CITY OF ALBUQUERQUE

**RE: U-Haul
8200 Jefferson Street NE
Conceptual Grading and Drainage Plans
Engineer's Stamp Date: No Stamp Date
Hydrology File: C17D146**

**RE: ENGINEERING PRE-SUBMITTAL COMMENTS/RESPONSES #1
8200 JEFFERSON STREET NE / U-HAUL DEVELOPMENT**

GRADING AND DRAINAGE PLAN

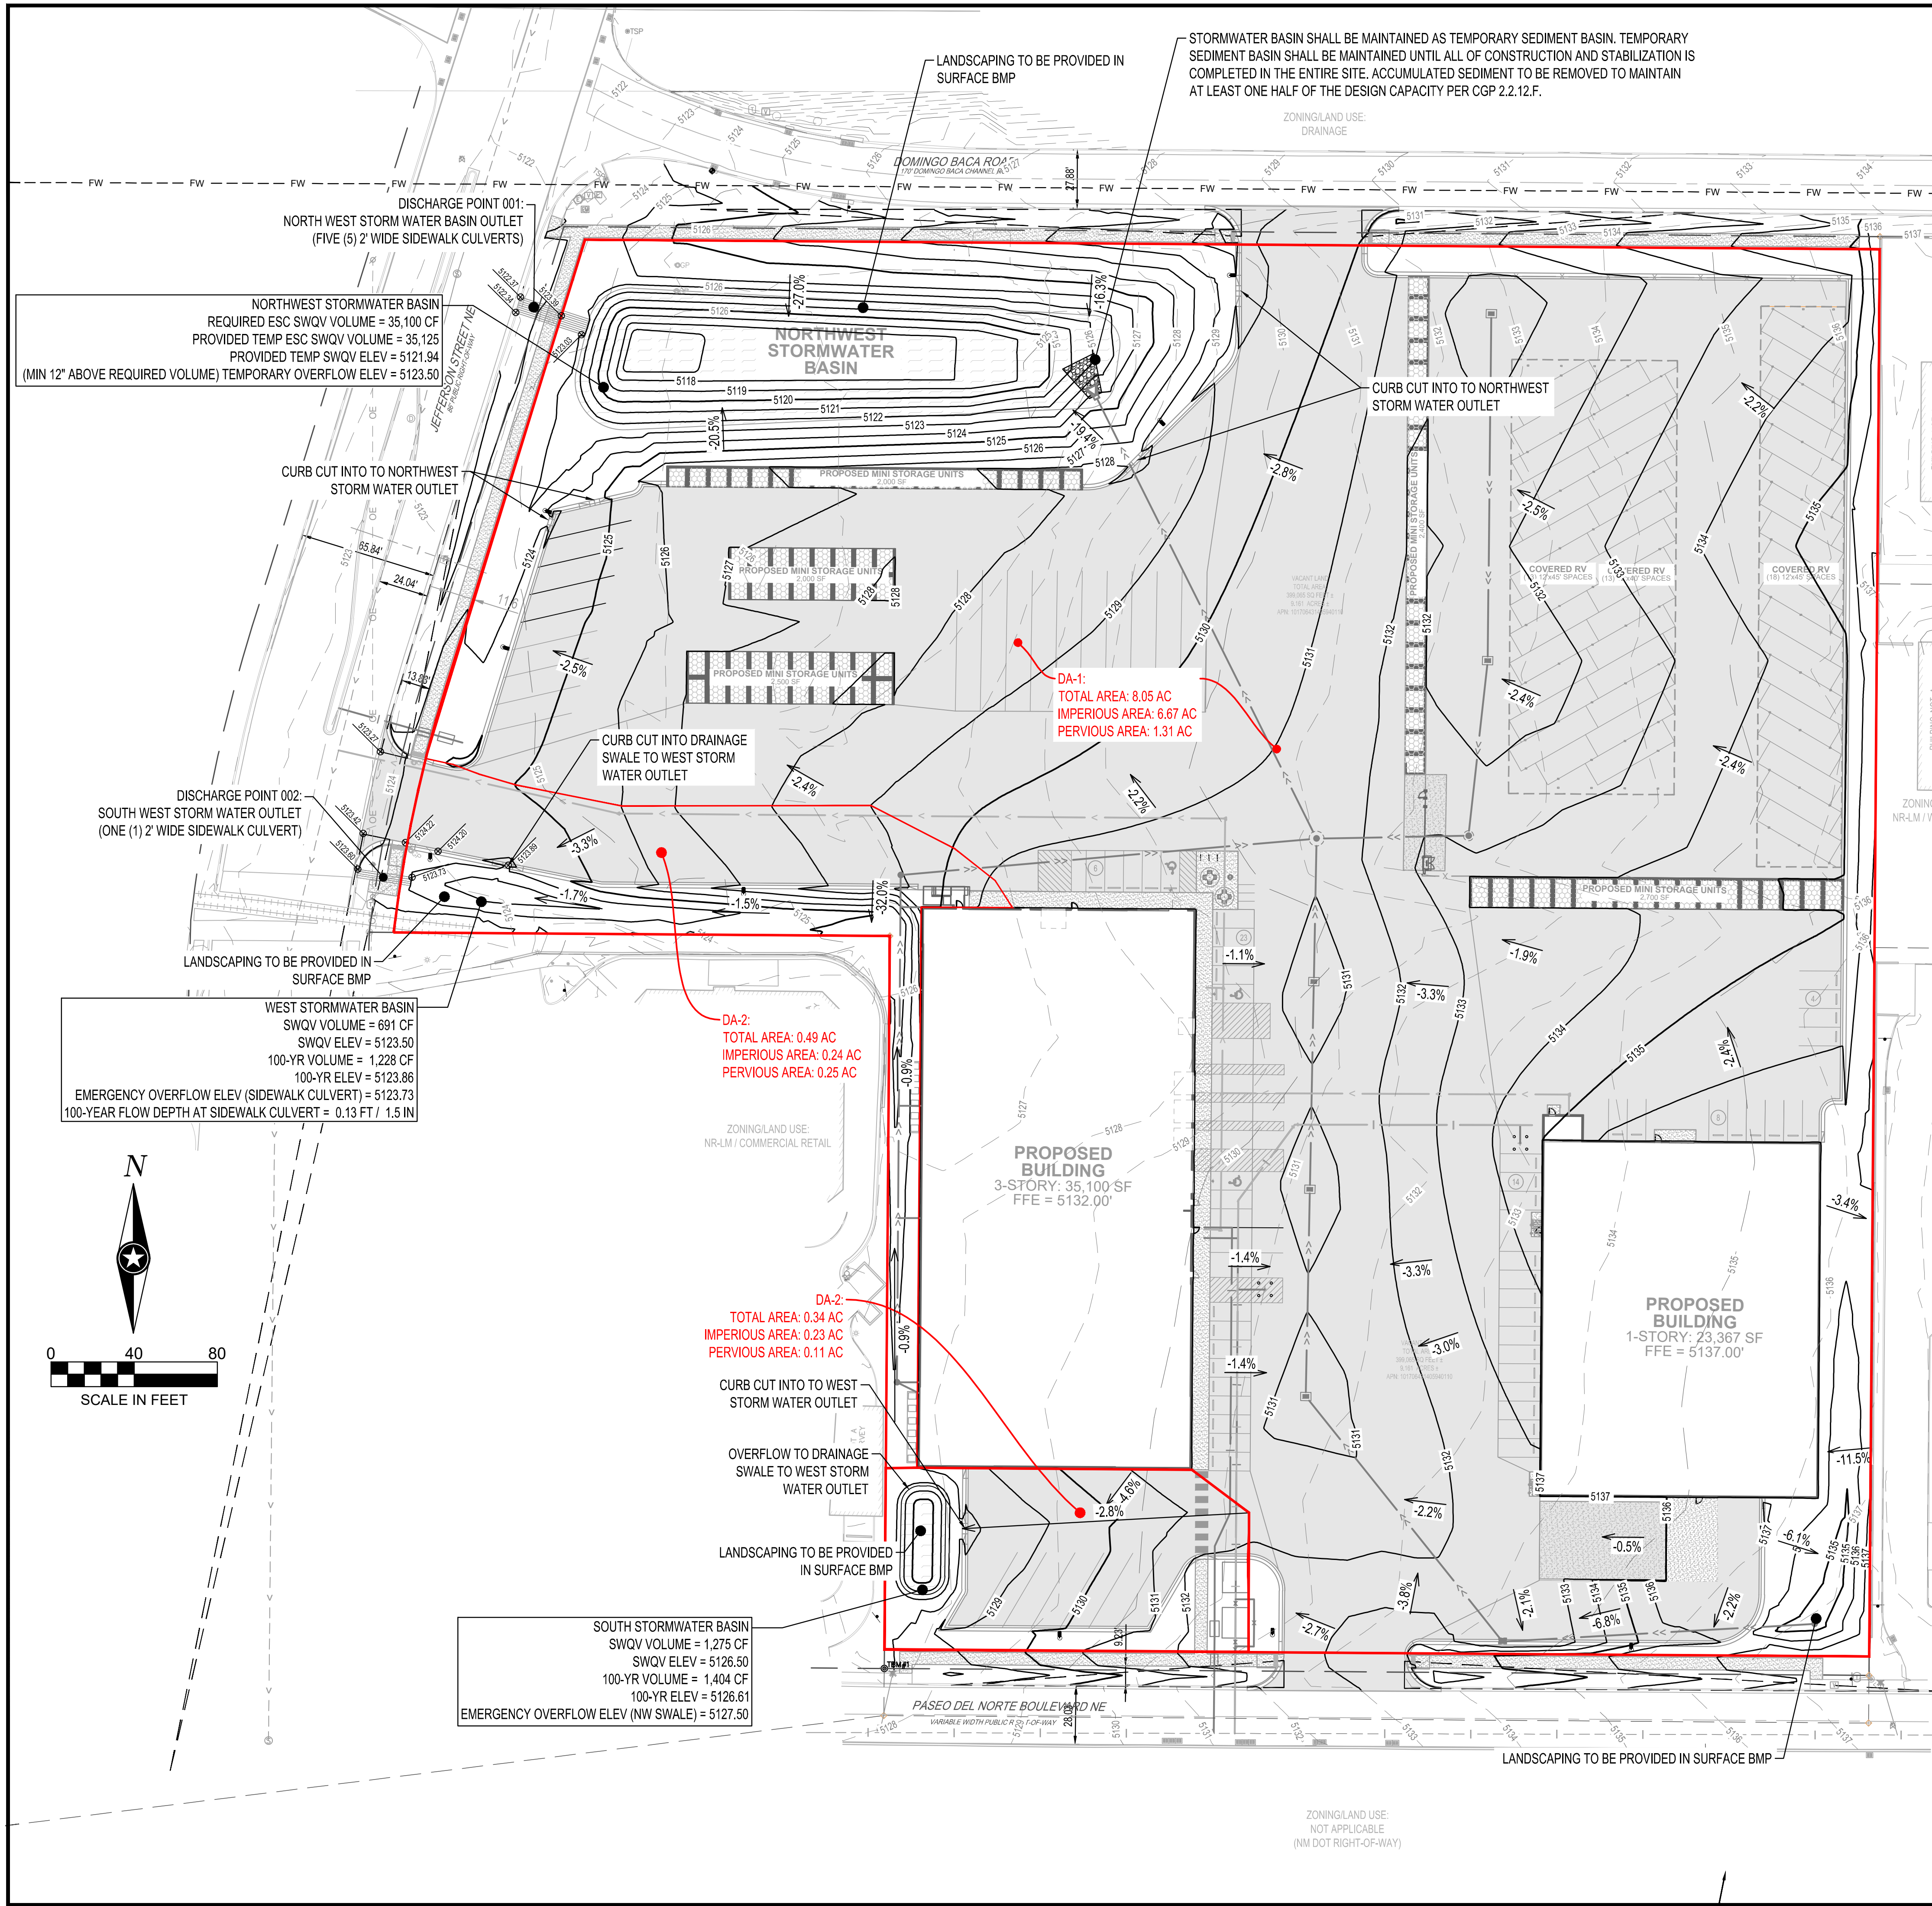
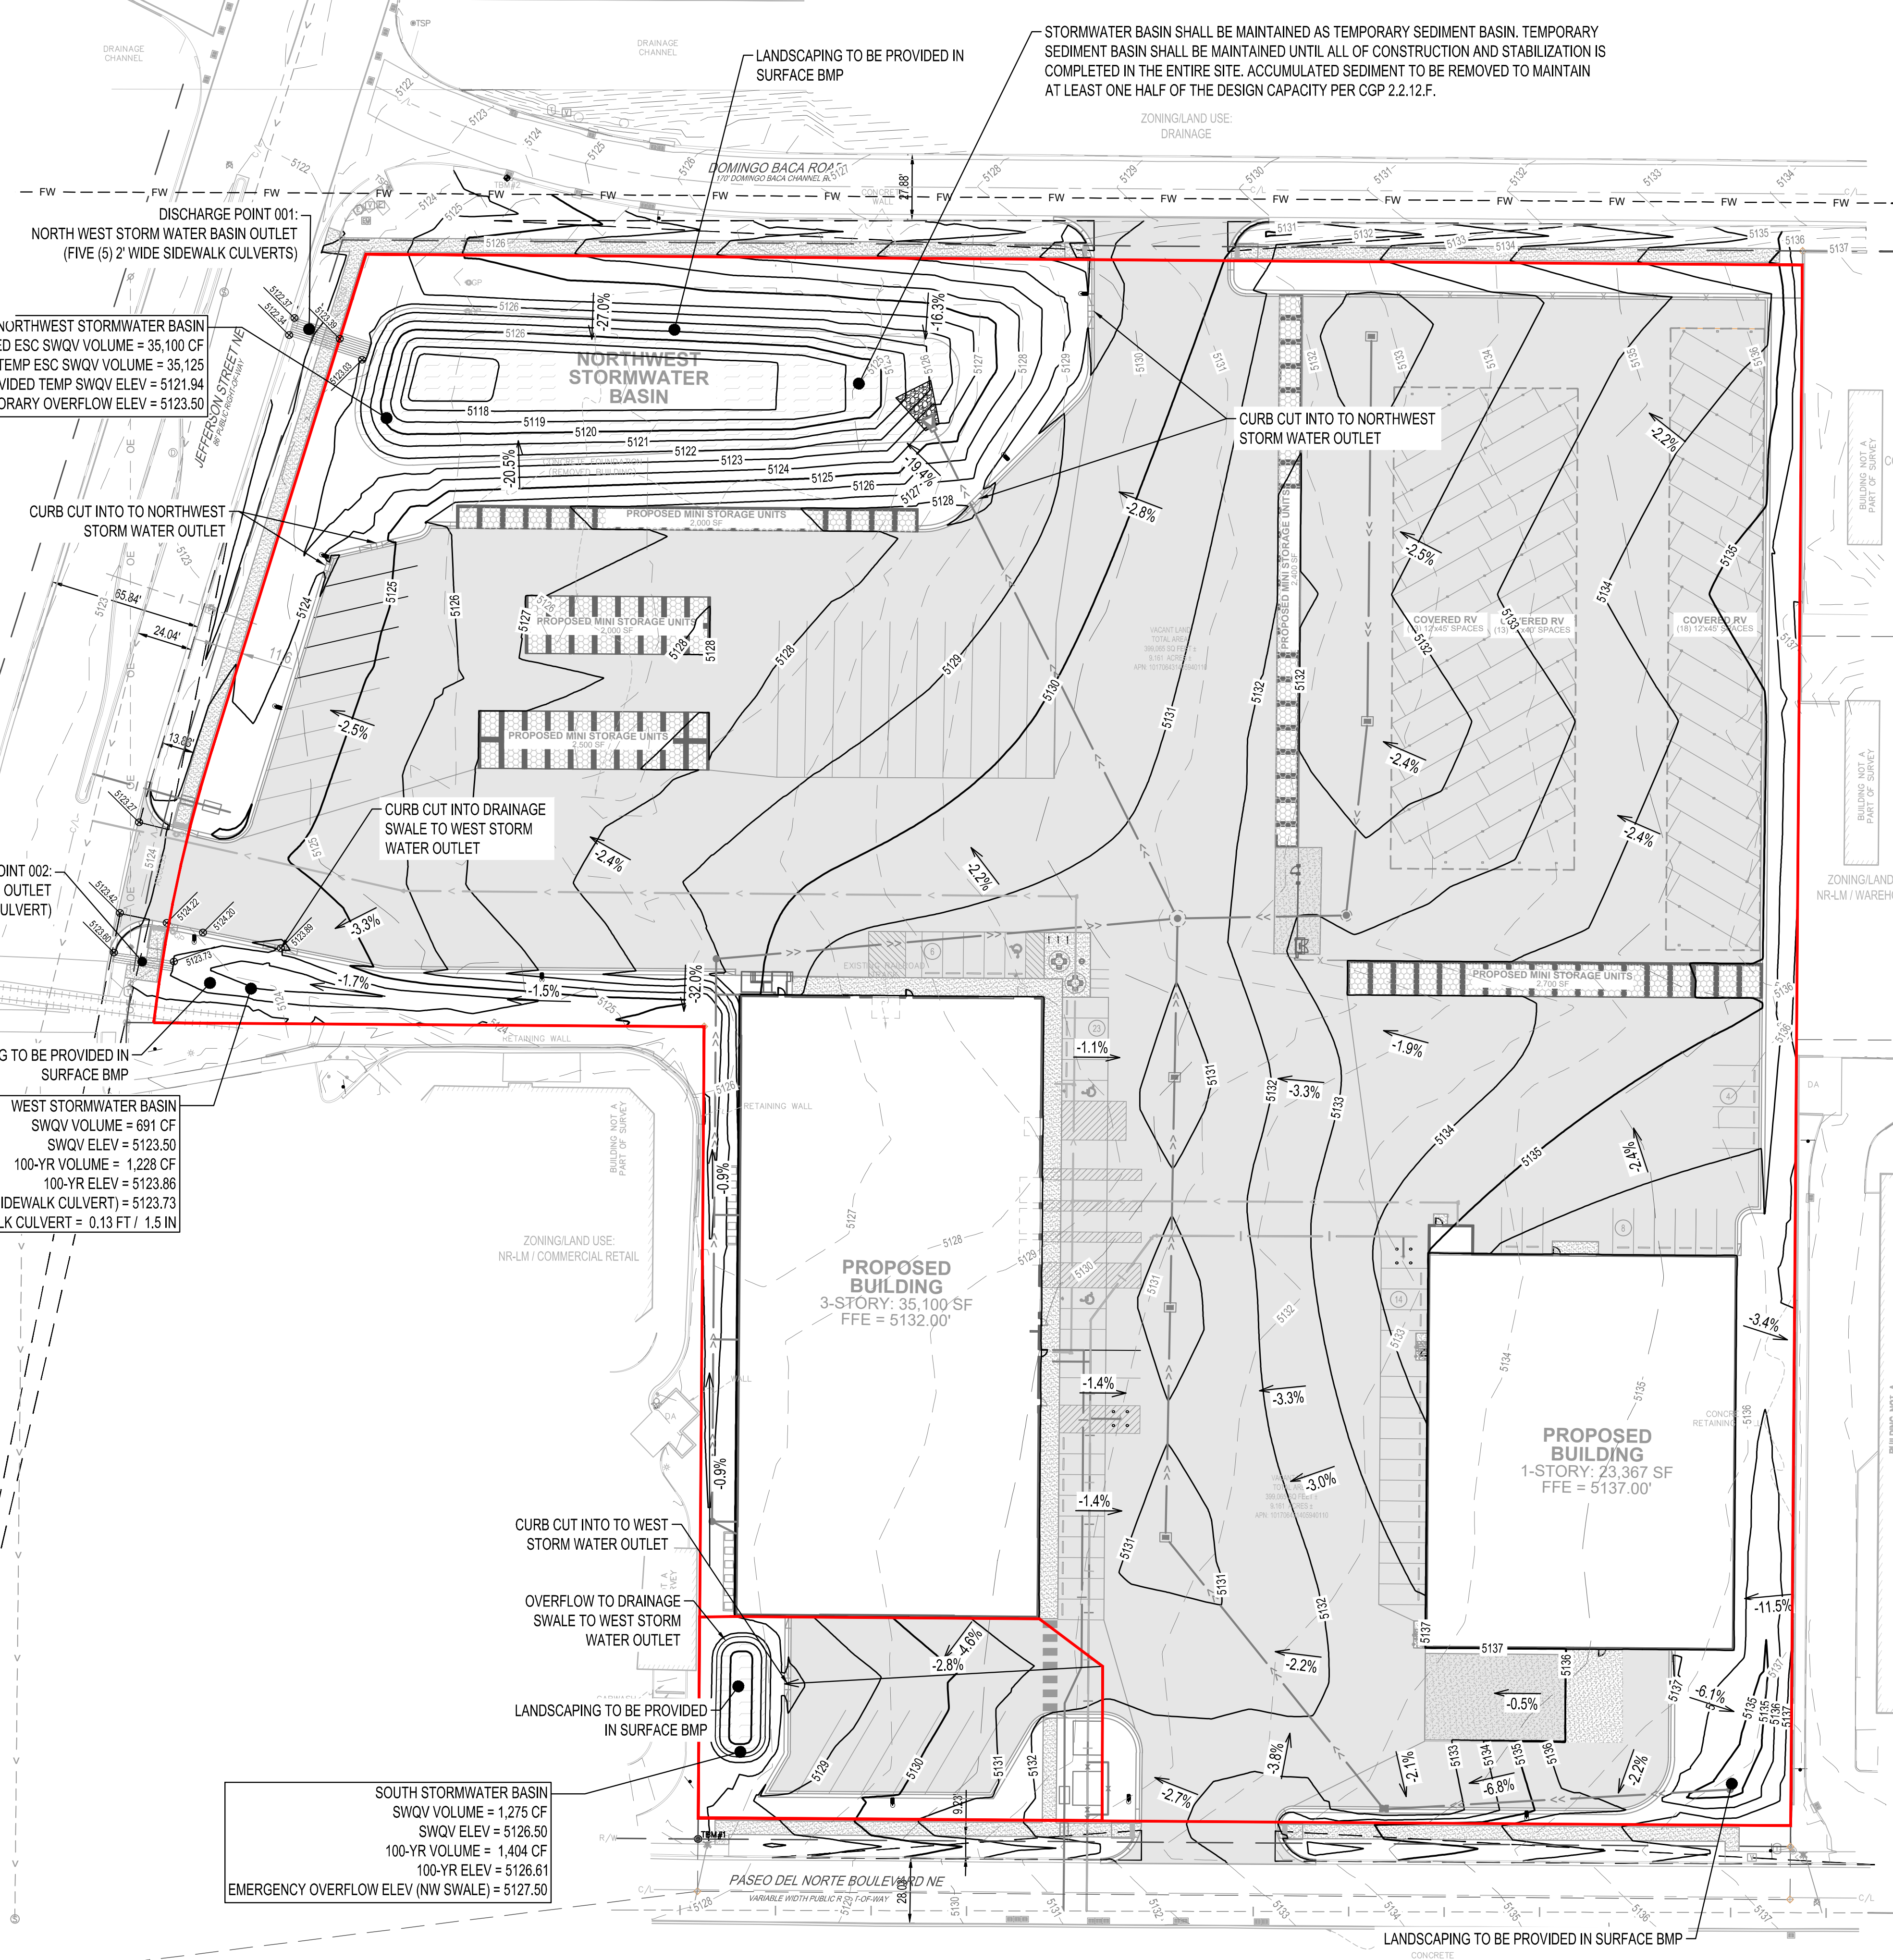
2. Please use the procedure for 40 acre and smaller basins as outlined in Development Process Manual (DPM) Article 6-2(a). Please provide both the existing conditions and proposed conditions for the 100 year-6 hour storm event.

3. Please follow the DPM Article 6-12 Stormwater Quality and Low-Impact Development for the sizing calculations. To calculate the required SWQV, multiply the impervious area (Square feet) draining to the BMP by 0.42 inches for new development sites divided by 12 to get the required volume in cubic feet. The calculations of both the required and the provided volume of each BMP must be shown on the Grading and Drainage Plan. Each BMP should be labeled on the Grading and Drainage Plan with the required SWQV and associated water surface elevation and the 100-year water surface elevation. Landscaping of surface BMPs is also required to be noted on the Grading and Drainage Plan.

4. Please show the existing railroad spur that goes through the property along with the railroad easement.

5. The Site Plan shows a proposed building and site work over the existing railroad spur and railroad easement noted in Comment #4. Please provide a notarized letter from the owner of the existing railroad easement stating that construction can be done on their easement.

6. Since there is an existing railroad spur through the site as indicated in Comment #4, the site will have two separate drainage discharge points. The southern portion drains to a Stormwater Quality Pond with an emergency spillway as a sidewalk culvert to Paseo de Norte Access Rd. The northern portion drains to a Stormwater Quality Pond with an emergency spillway as a sidewalk culvert to Domingo Baca Rd.

7. Please provide the weir calculations, per DPM Article 6-16(A), for the curb cuts and sidewalk culverts. A coefficient of 2.7 is typically used for the weir equation $Q = CLH^{2/3}$.

8. A waterblock, 0.87' high, per COA Paving Detail No. 2426, is required at the driveway entrance.

9. Please note Paseo del Norte Access Road is within NMDOT jurisdiction. Since this project runoff goes into the New Mexico Department of Transportation's (NMDOT) Right of Way, written concurrence must be obtained from NMDOT D3 Drainage that this project can proceed. Please contact Tim Trujillo P.E (TimothyR.Trujillo@state.nm.us or 505-373-4987).

10. Add a note on the Grading Plan, "Prior to any work within the New Mexico Department of Transportation (NMDOT) Right-of-Way, an NMDOT permit will be required." Provide a copy of the issued permit prior to requesting Certificate of Occupancy.

ISG Response: Stormwater calculations have been revised to match this requirement.

ISG Response: Calculations have been provided on the G&D Plan.

ISG Response: Existing railroad line is removed from the plans as it will be removed as part of this project. See below response for comment #5 regarding this in more detail.

ISG Response: Documentation has been provided between the NMDOT and City of Albuquerque planning staff that this railroad line can be removed as it is no longer connected to the NMDOT railroad and U-Haul owns the line that runs across this site.

ISG Response: Railroad to be removed as part of this project and will not be split into a north and south drainage area based on the railroad's placement on the site due to it being removed. There will be two stormwater outlets of this site on Jefferson ST NE,, one in the northwest corner and one in the southeast corner. No other locations work for outlets onto the site due to elevation constraints of the outlets and roadway elevations.

ISG Response: Weir/channel calculations provided in this report.

ISG Response: A water block over 1 ft high is provided at the west driveway entrance.

ISG Response: NMDOT has been contacted and Tim Trujillo has provided acceptance to our plans per the attached email.

ISG Response: Note has been added.
